17 May 2022

Ref No: F2006/00524

RE: 42-52 RAYMOND AVENUE MATRAVILLE - MULTI LEVEL WAREHOUSE SSD 31552370

TITLE: WAREHOUSE GF PLAN

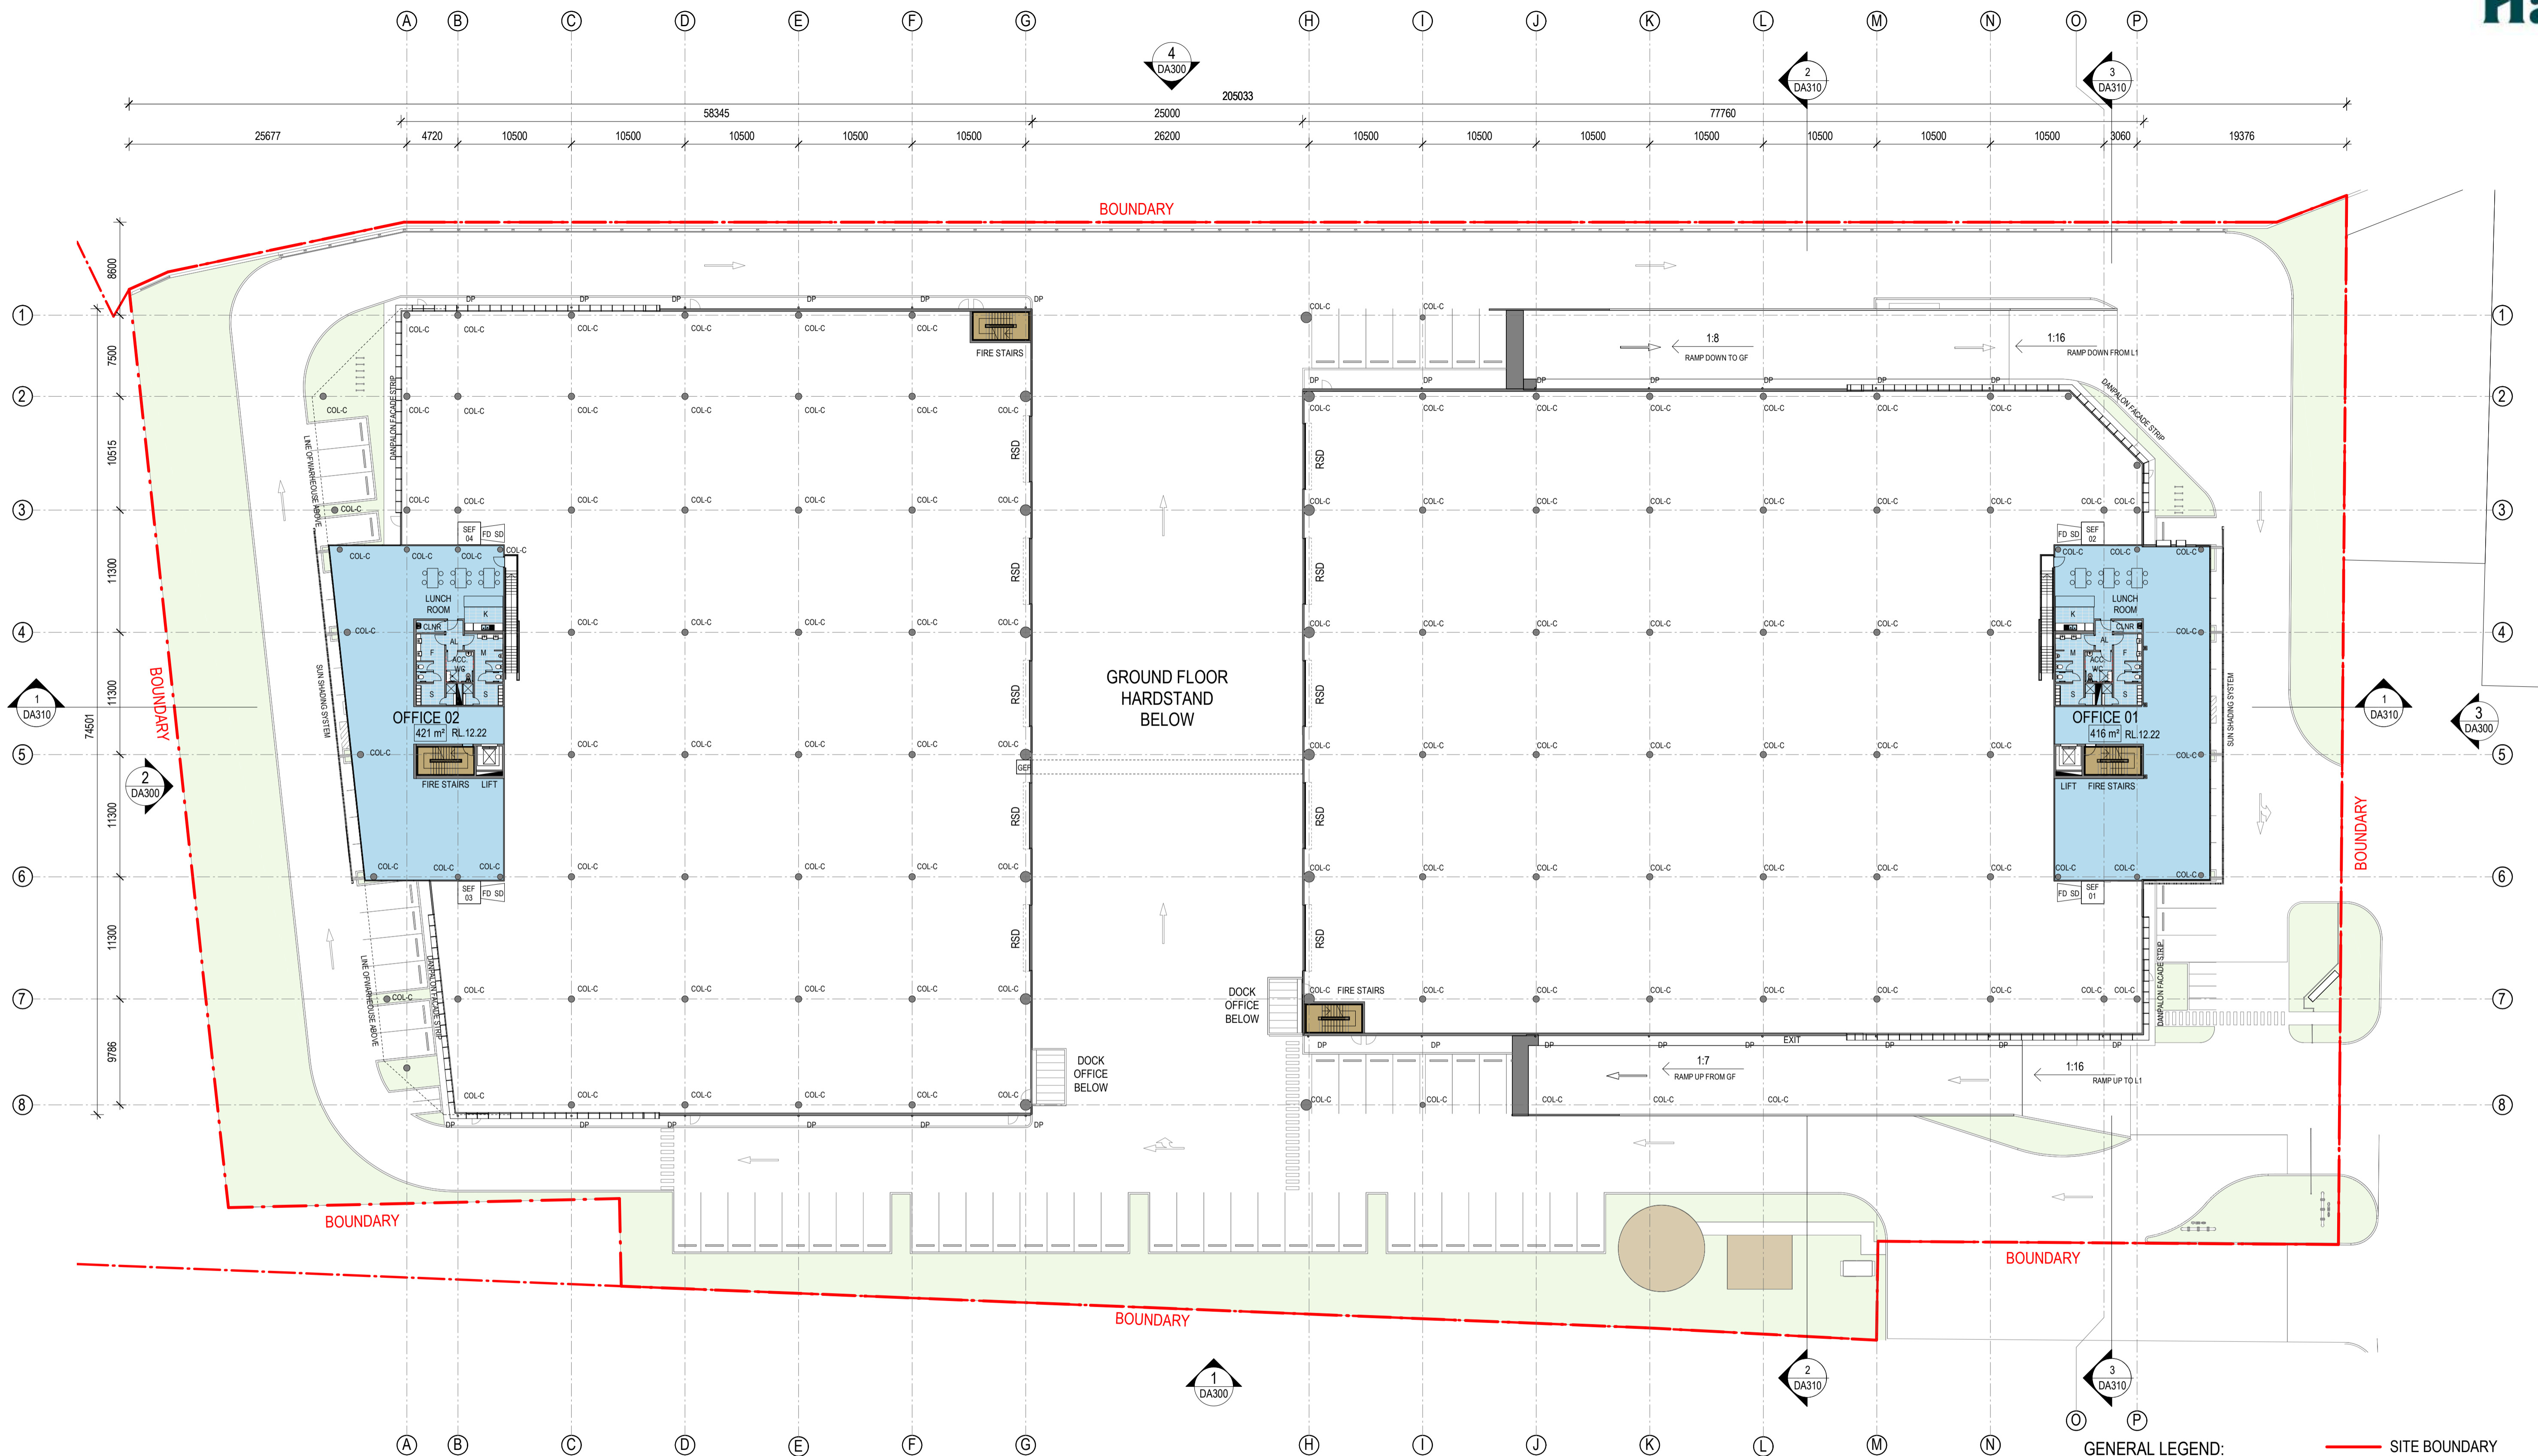
Following a site visit, Council noted what appears to be a second Hills Weeping Fig located within close proximity (southeast) to tree number 5 proposed for removal. This tree does not appear to have been identified in the Arborist Impact Assessment (AIA) provided in Appendix FF. Council requests clarification as to whether Tree 5 proposed for removal is multi stemmed, which may be due to a change in soil level surrounding the established tree, or whether there is an additional Hills Weeping Fig tree within close proximity of tree 5 not recognised on the AIA and whether this tree is too proposed for removal.

Council recommends that given the important visual and aesthetic values of the tree proposed for removal that further investigations be undertaken to ensure that this tree be retained and accommodated within expanded landscaped areas, on site with minimal branch and/or root pruning.

Any consent should include a condition requiring an amended landscaped plan showing expanded landscaped areas including permeable concrete/paving within the proposed development to meet the requirements of waterfront land under the Water Management Act.
